Application Ref:	3/2026/0477			 Ribble Valley Borough Council www.ribblevalley.gov.uk
Date Inspected:	31/07/26	Site Notice:	31/07/26	
Officer:	LW			
DELEGATED ITEM FILE REPORT:				REFUSAL

Development Description:	Proposed refurbishment, partial demolition and extension to existing dwelling.
Site Address/Location:	Moorcot, Nickey Lane, Mellor, BB2 7HF.

Client: Nigel Stones		
Project: Proposed Alterations Moorcot Nickey Lane Mellor		
Dwg title: Proposed Site Plan		
Scale @ A4: 1:200	Date: 24.06.26	Drawn by: PD
Drawing no. 1861 - 102		Rev. B

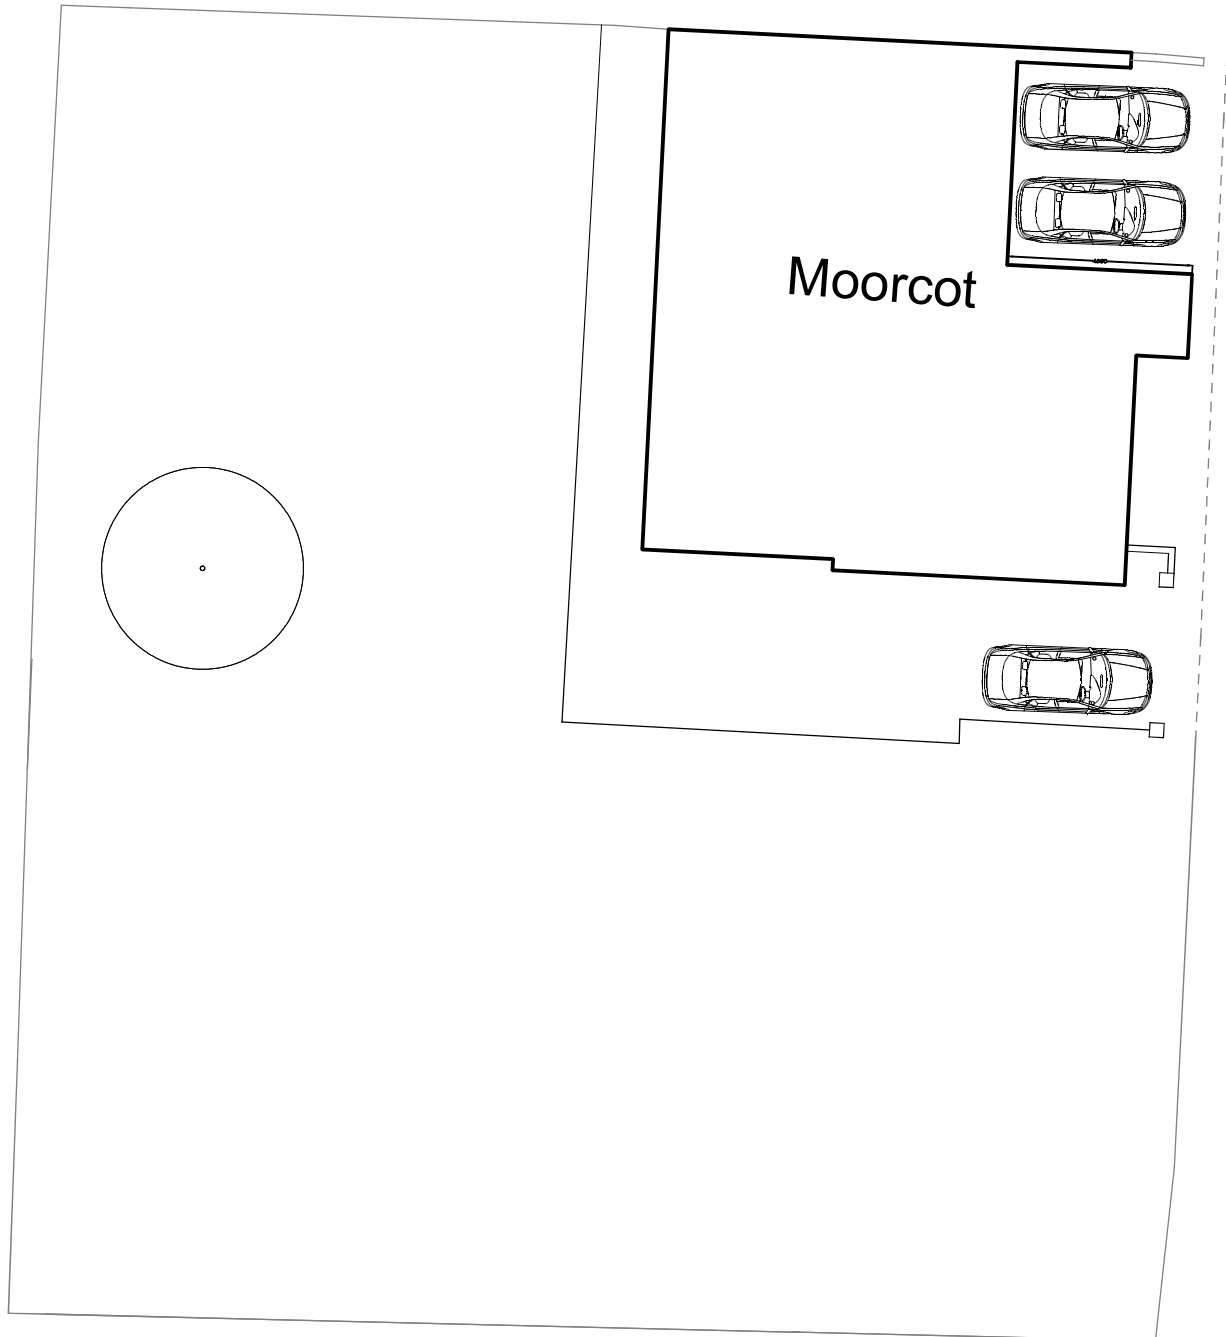
An initial consultation response from Lancashire County Council Highways, acting as the Local Highway Authority (LHA), was received on 6th August 2026. Within this response, the LHA sought clarification regarding a number of discrepancies identified within the submitted plans relating to the proposed parking arrangements.

In response, the applicant submitted revised Site Plans and an amended Proposed East Elevation drawing. These documents were subsequently reviewed by the LHA, with updated comments received on 12th August 2026. The LHA notes that the parking arrangement to the north-east of the dwelling had been amended and now shows parking partly accommodated beneath the proposed car port. No objection is raised to this reviewed layout. However, the LHA has requested that the parking area be surfaced in a bound porous material to prevent loose surface material from being deposited onto the public highway. This requirement can be secured by condition.

The LHA also raised concerns regarding the existing surface water drainage arrangements, noting that runoff from the garage roof and associated downpipes at the front of the property currently discharge directly onto the highway. The LHA advises that surface water should not discharge onto the adjacent public maintained highway network and has therefore requested a condition requiring all surface water to be directed to appropriate drainage outfalls within the site curtilage.

The Local Highway Authority (LHA) has recommended that the northern boundary wall be lowered by approximately one and a half brick courses in order to improve visibility for vehicles entering and leaving the parking area. Notwithstanding this advice, the wall forms part of an existing arrangement that already affects visibility for vehicles accessing the garage. As the proposed development would not materially worsen the existing situation, it is not considered reasonable to require alterations to the wall through a planning condition.

Client: Nigel Stones		
Project: Proposed Alterations Moorcot Nickey Lane Mellor		
Drawing title: Proposed North Elevation		
Scale & A3:	Date:	Drawn by:
1:50	10.06.26	PD
Drawing no.	Rev.	
1816 - 07	-

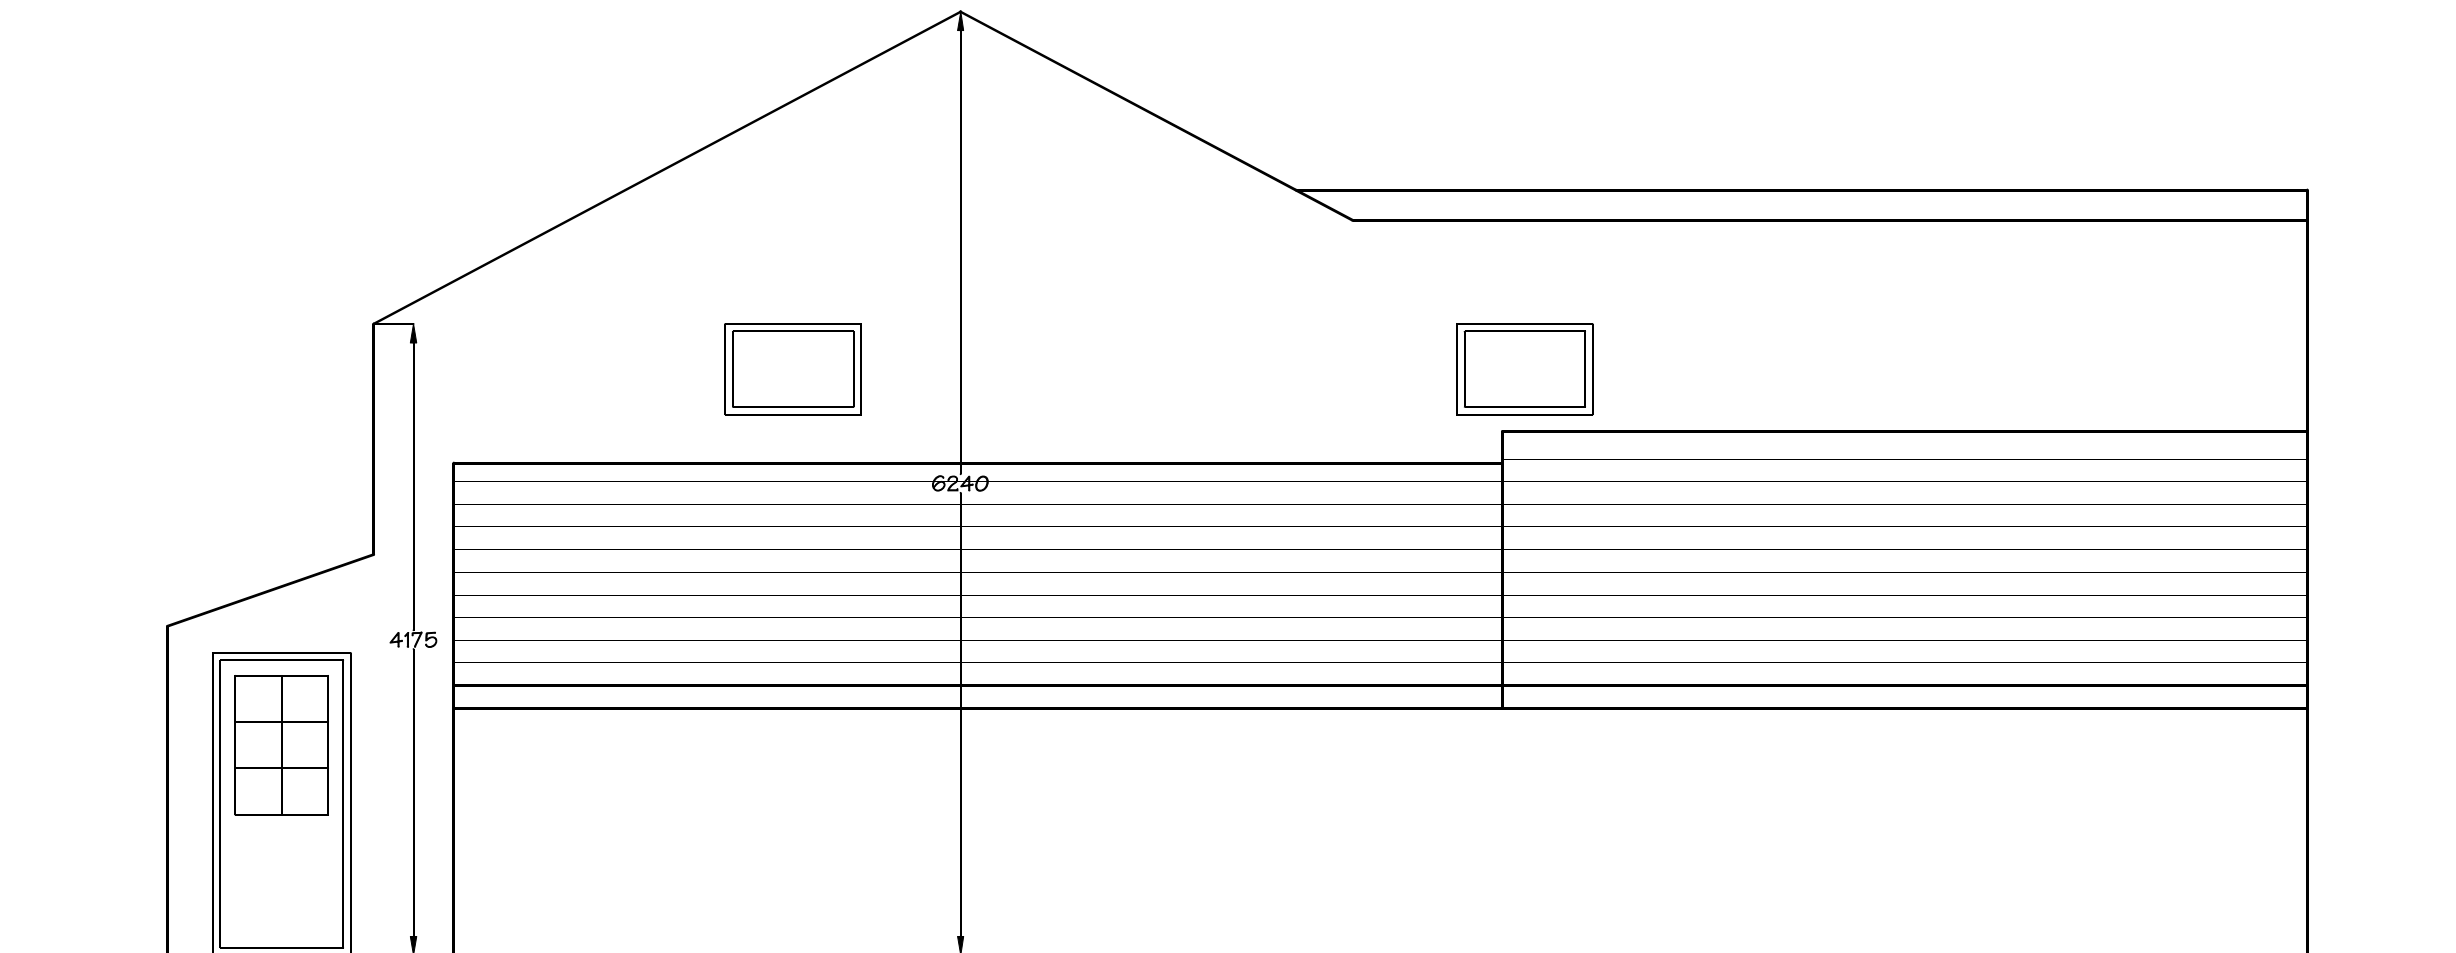
The proposed alteration to the north-facing elevation, comprising the relocation of the existing first-floor bathroom window, is also considered acceptable. Subject to a condition requiring the window to be obscurely glazed, consistent with the existing arrangement, the proposal would not give rise to any additional opportunities for overlooking or result in an unacceptable loss of privacy for the occupants of No. 22 Nickey Lane.

Client: Nigel Stones		
Project: Proposed Alterations Moorcot Nickey Lane Mellor		
Drawing title: Proposed West Elevation		
Scale & A3:	Date:	Drawn by:
1:50	10.06.26	PD
Drawing no.:	Rev:	
1816 - 10	-

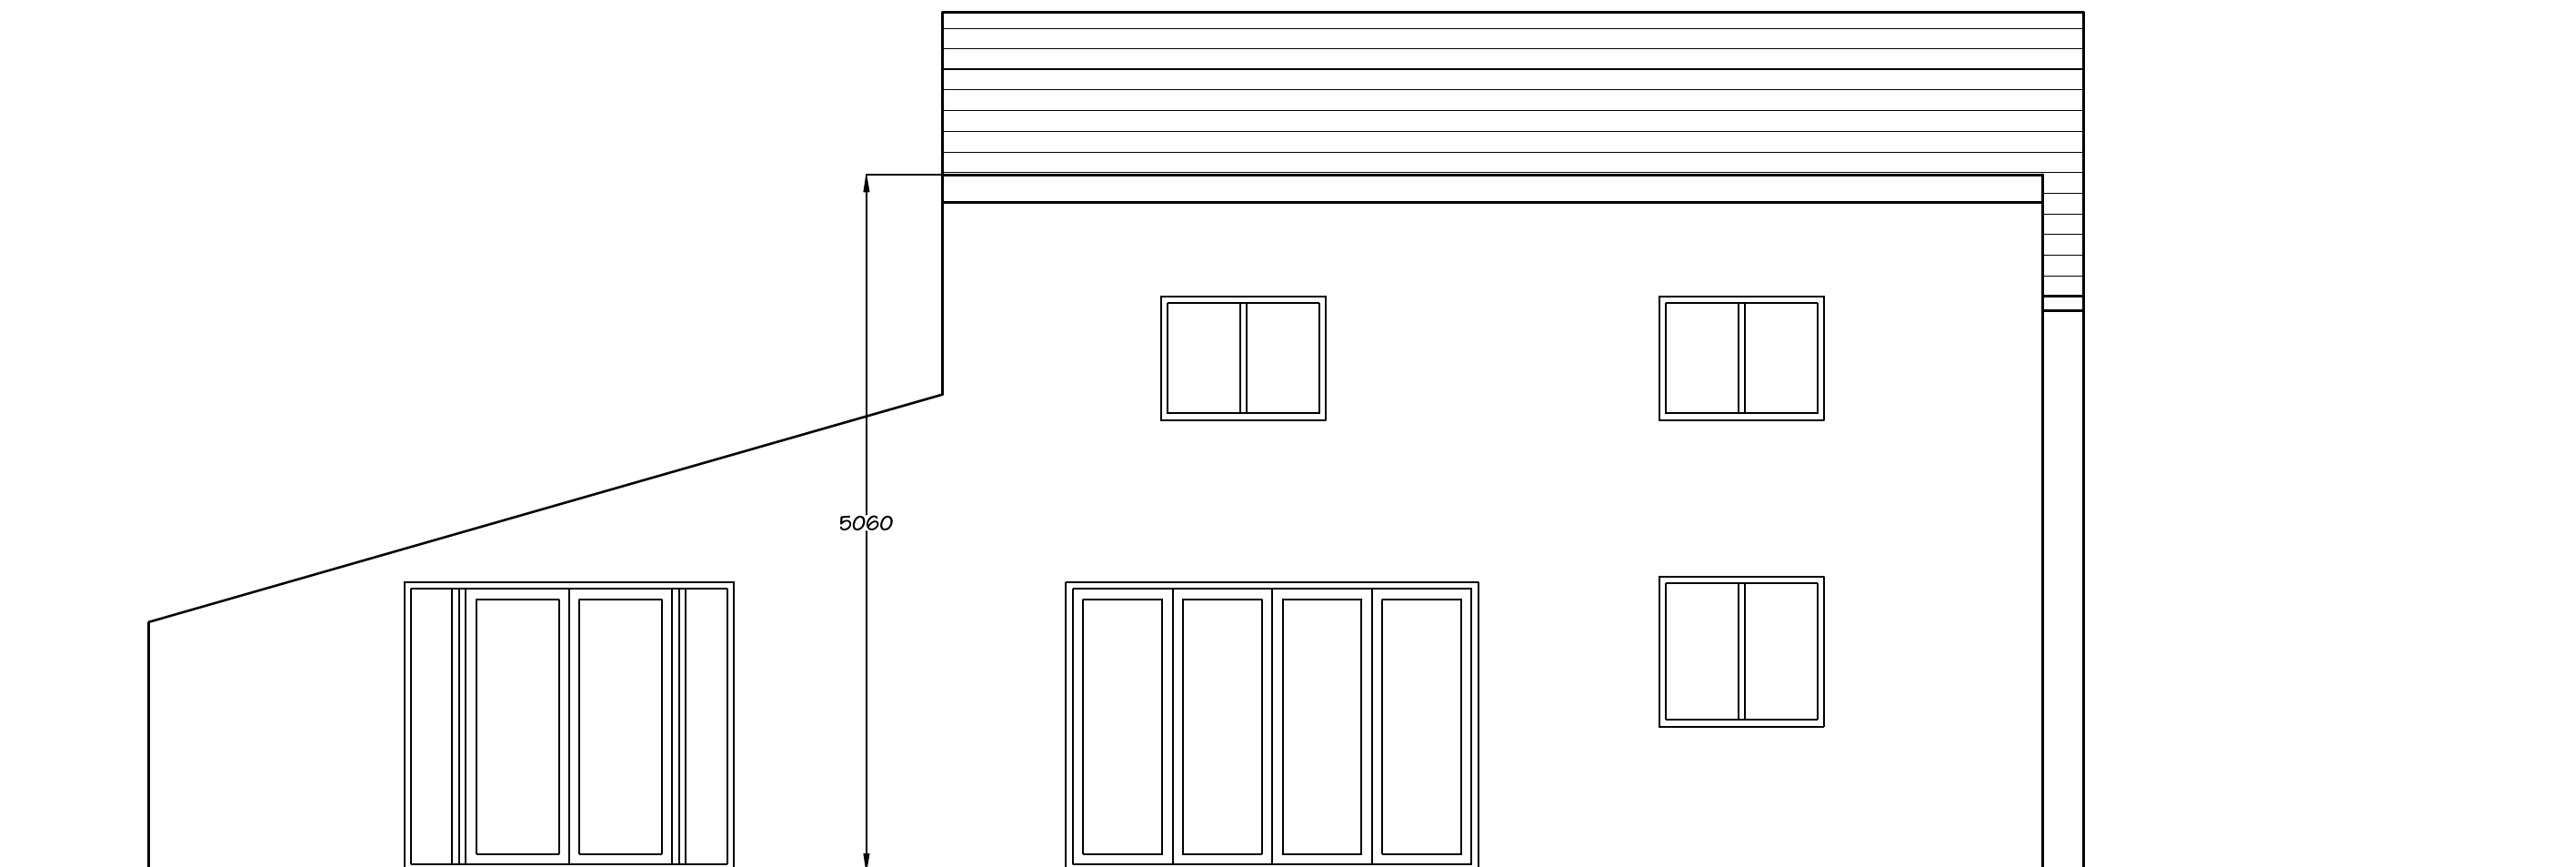
The proposal comprises a substantial extension to a traditionally designed dwellinghouse constructed in stone, render and slate. The extension would project approximately 5m beyond the existing rear elevation and span a total width of approximately 13.8m. Whilst the proposed materials would broadly reflect those of the existing dwelling and assist in achieving a degree of visual integration, significant concerns arise in respect of the overall scale, massing and design of the development.

In particular, the proposed two-storey flat-roofed element would extend across the majority of the rear elevation of the primary dwelling, resulting in a form of development that appears incongruous with the traditional character and proportions of the host property. The scale and breadth of the extension, combined with the flat-roof design, would create an overly dominant and bulky addition that would fail to respect the character of the main dwellinghouse. As such, the proposal would not respond positively to its immediate context.

The Local Planning Authority acknowledged that the proposal would replace an existing two-storey flat-roofed rear extension approved in 1967 under historic planning application reference 6/9/2437. However, the existing extension is considerably smaller in scale, measuring approximately 3.7m in width compared to the proposed 8m width. Consequently, the visual impact of the proposed development would substantially exceed that of the existing extension. Furthermore, the existence of a previously approved flat-roofed extension does not, in itself, justify a materially larger replacement, particularly where current

Moreover, the resulting visual harm would not be confined solely to private views. The application property occupies a prominent position, being a two-storey dwelling set within a street scene of predominantly comprising bungalows, with its gable elevations readily visible from Nickey Lane when approaching from both the north and south. Whilst the appearance of the northern gable elevation would remain broadly comparable to that existing, the enlarged flat-roof extension would be noticeably more prominent in views from the south owing to its proximity to the southern gable wall, being in by approximately 0.3m. As a consequence, the extension would appear as an unduly unsympathetic feature that would detract from the character and appearance of the dwelling and the wider street scene.

The proposed development, by virtue of its scale, massing and flat-roof form would result in the introduction of an incongruous and unsympathetic form of development that would fail to respond positively to, or enhance, its immediate context. The development would therefore be of detriment to the visual amenities and character of the application property and wider street scene, contrary to the aims and objectives of Policy DMG1 of the Ribble Valley Core Strategy and Policy DP3 of the National Planning Policy Framework.
